Your ref: MP 05_0129 MOD 3
Our ref: (0698/09DA & 0098/20DM)

5 March 2020

Notification of Modification – Lakes Estate Residential Subdivision (MP 05_0129 MOD 3)

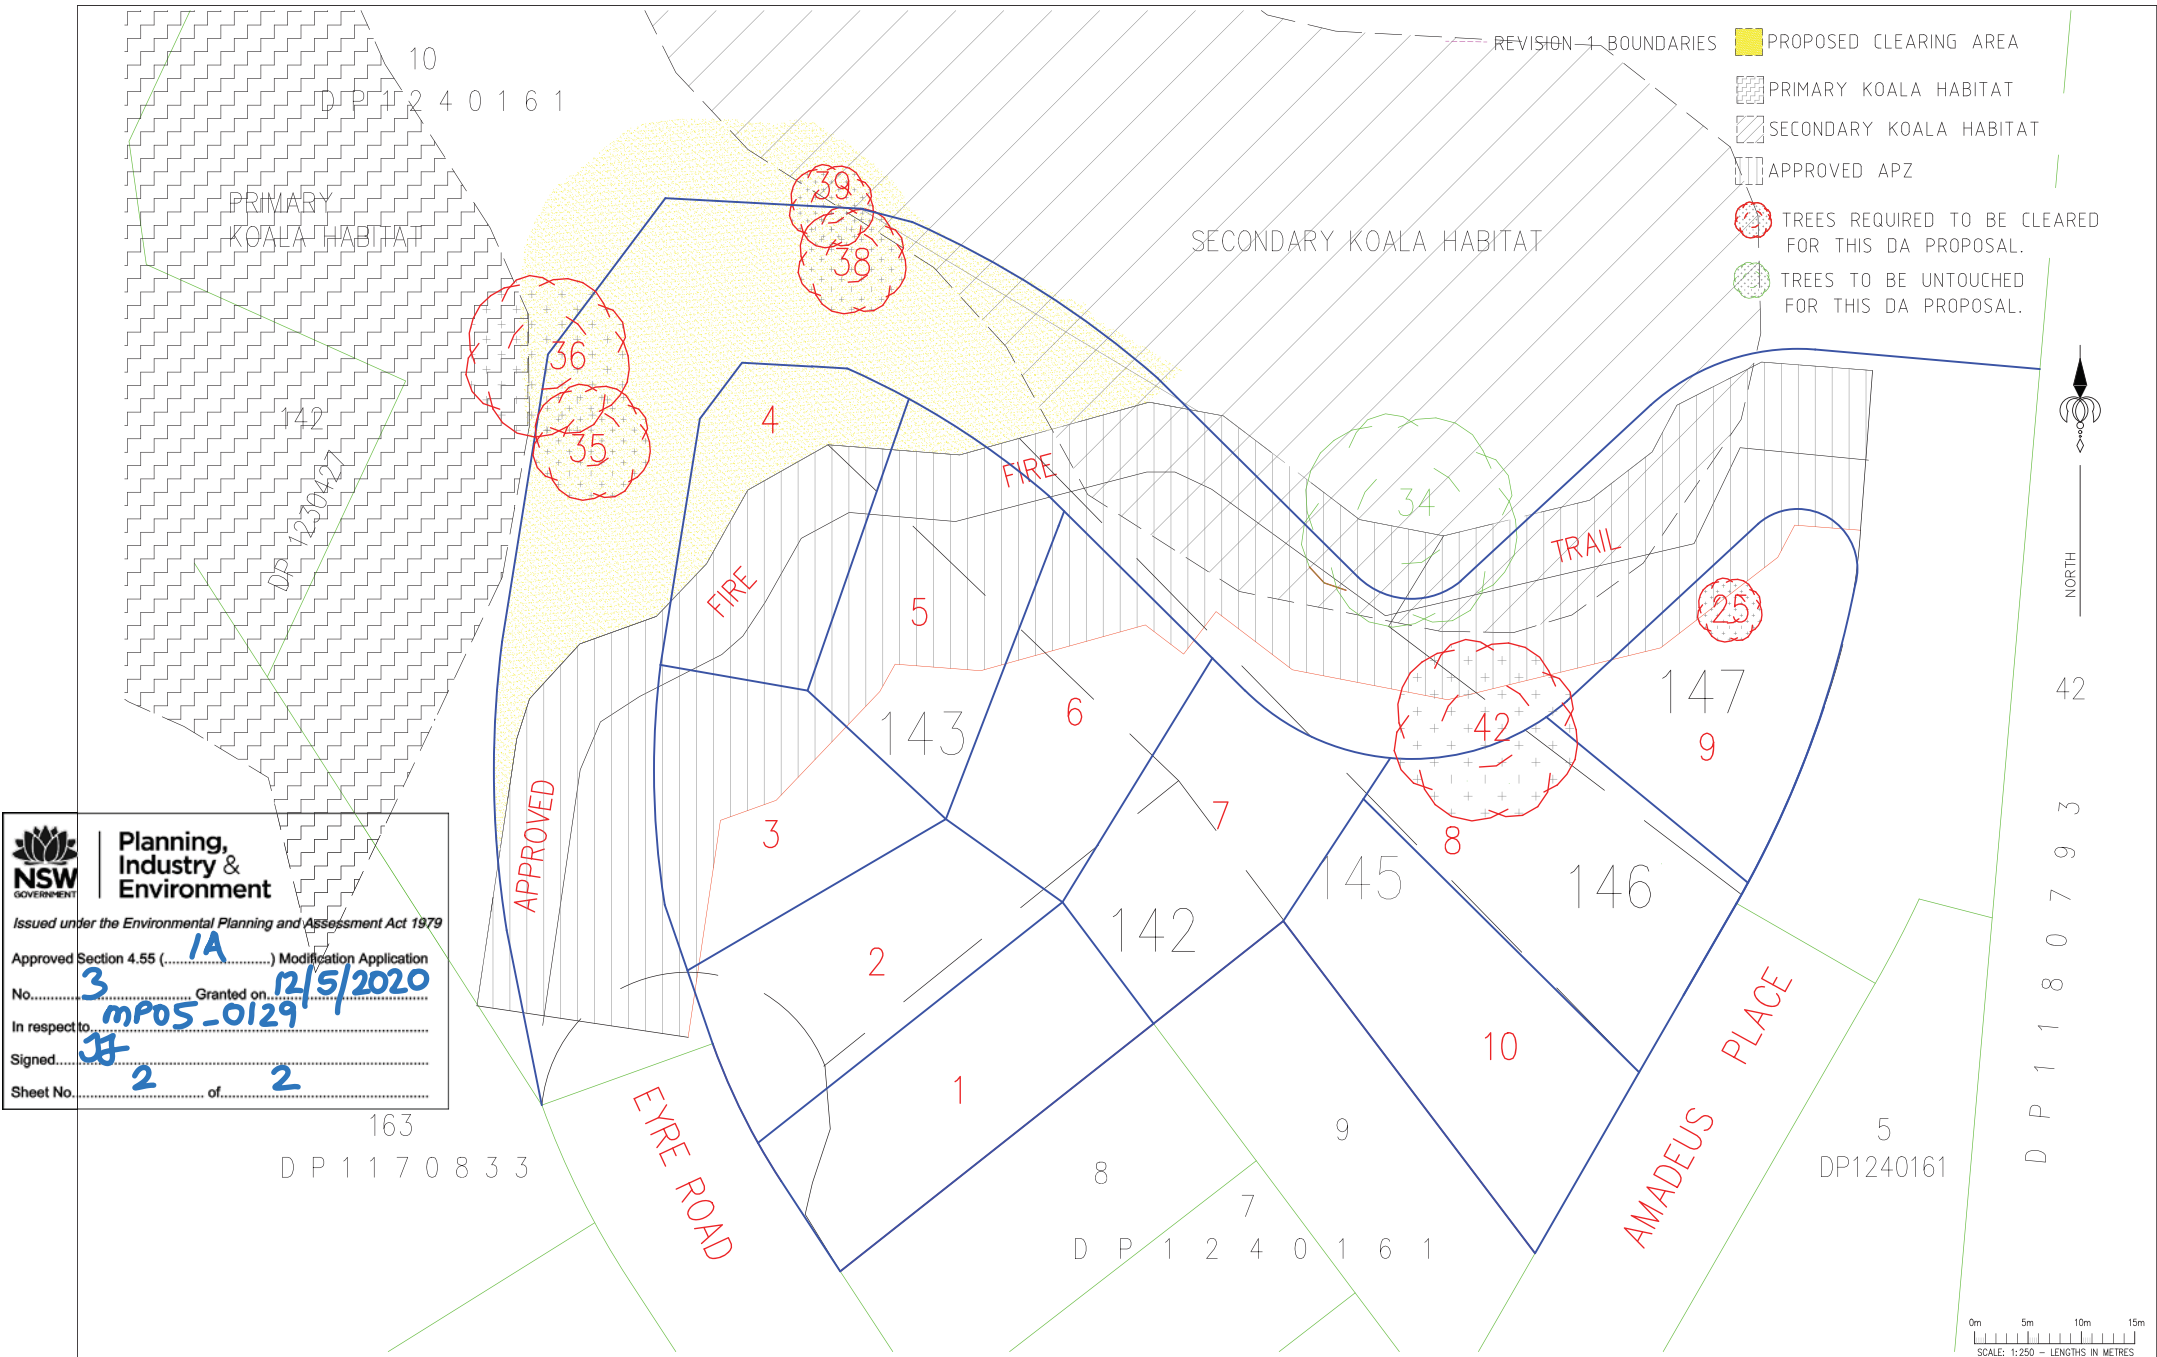
- It is noted that the proposed road width does not comply with Planning for Bushfire Protection 2006, which requires a minimum width of 8 metres, as specified in Section 4.1.3. It is recommended that this matter be raised with the NSW Rural Fire Service and that the applicant be asked to amend their plans to demonstrate compliance with this requirement.

- The submitted plans show Road no.1 being extended to the north. Council does not support this, given that this extension does not service an approved residential area to the north and that this extension creates an intersection, which may not comply with required sight distances and grades. It is requested that the applicant be asked to remove this northern extension of Road no.1.

- Sheet 4 of the submitted plans shows retaining walls at the boundary. It is unclear, however, whether these walls are proposed to be located on private property or the road reserve. In this regard, Council will not agree to retaining structures being located within the road reserve. It is requested that the applicant be asked to clarify (on plan) where the proposed structures sit.
